**Consultation Response from KC,
Lead Local Flood Authority**

2026/91264 Land off Lindley Moor Road, Lindley, Huddersfield, HD3 3SX

Discharge of details reserved by conditions 12 (Structures in HW), 15 (surface water strategy), 16 (exceedance routing), and 17 (oil interceptor) on previous permission 2022/91477 for Hybrid Planning Application for erection of industrial unit for B2 /B8 use, with ancillary office space and associated access, parking, groundworks and landscaping in conjunction with outline application for mixed use development use class E(b),B2 and B8, with ancillary office space and associated works

Drawing Title
SITE WIDE DRAINAGE LAYOUT

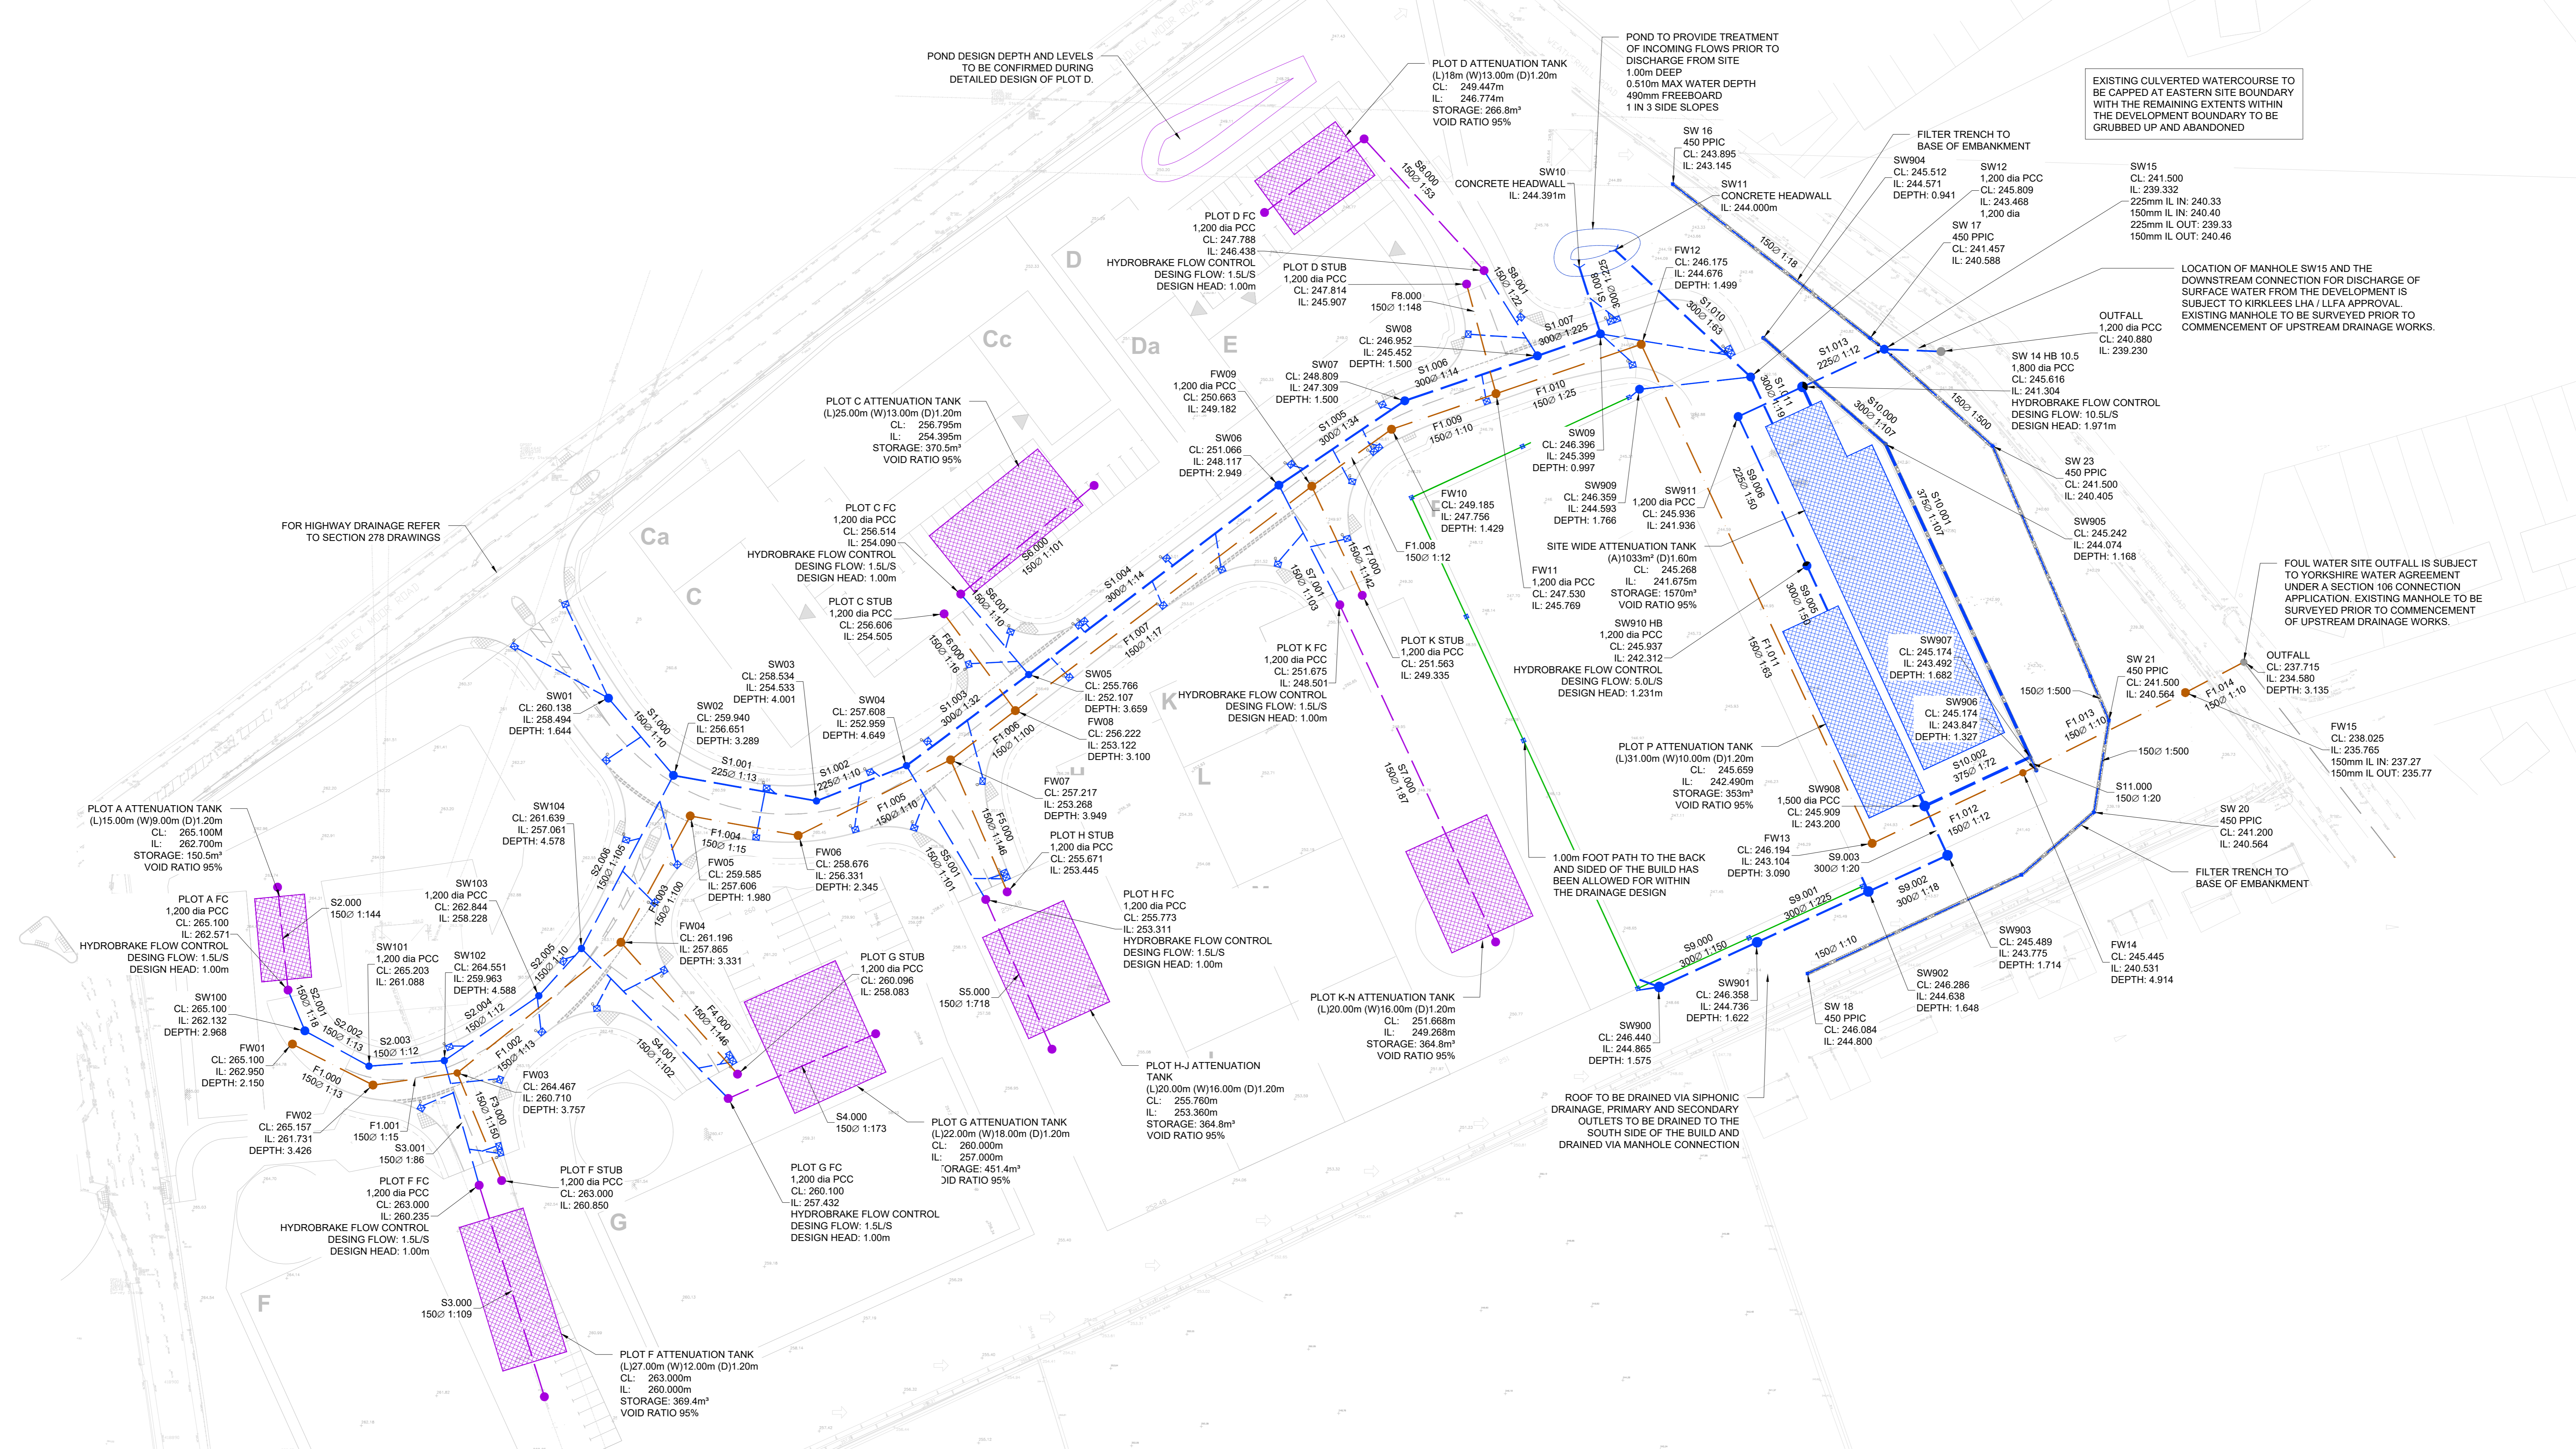
To discharge this condition a 10.5l/s restriction of surface water to a defined local watercourse is required. The submitted primary method of discharging to highway drain is not permitted and should be removed from the submission.

The LLFA reject the use of tanks and flow controls on individual plots with under 3l/s as a minimum 75mm orifice size has to be achieved.

Tank dimensions must be listed on drainage plans to be cross referenced with hydraulic calculations.

ALTERNATIVE SITE WIDE DRAINAGE LAYOUT OPTION B OUTFALL

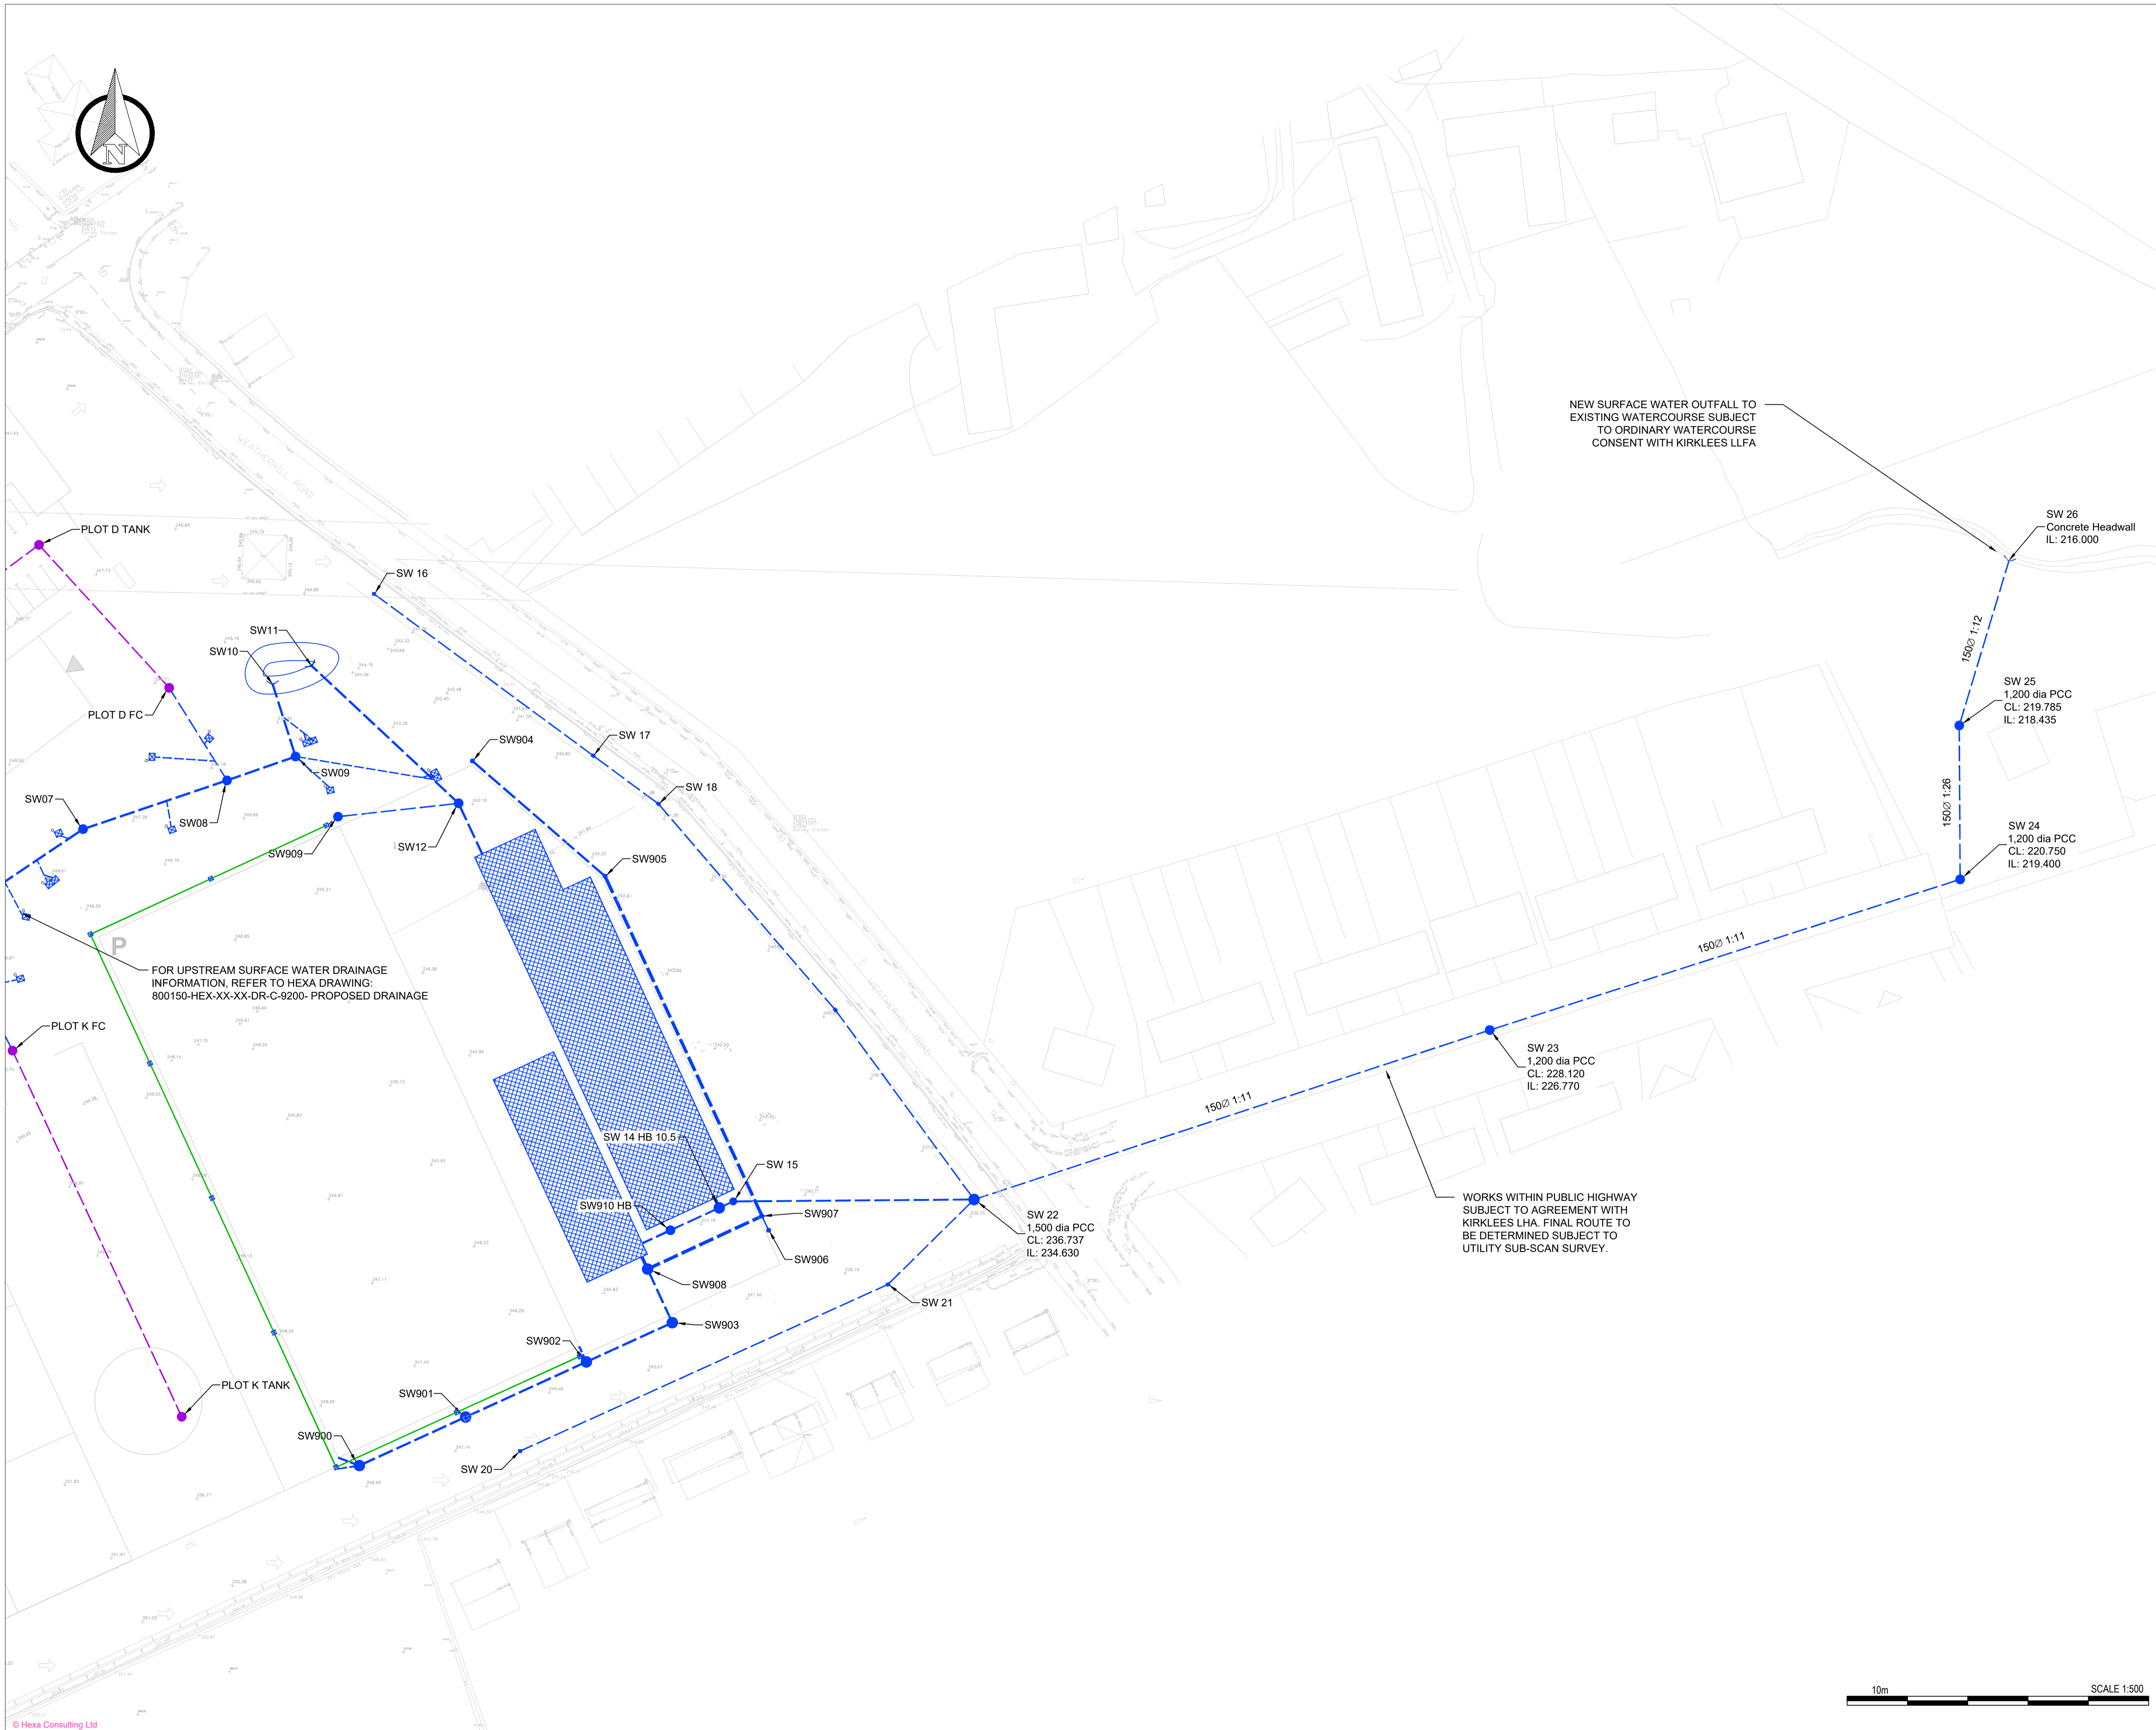
An alternative scheme submitted is acceptable (In terms of discharge rate and outfall location) but as the drain crosses Kirklees land and outfalls to the watercourse, immediate dialogue with Gary Fowler, Estates Manager, to establish the landowner's permission to connect is required. The LLFA permission from a land drainage perspective is sanctioned.
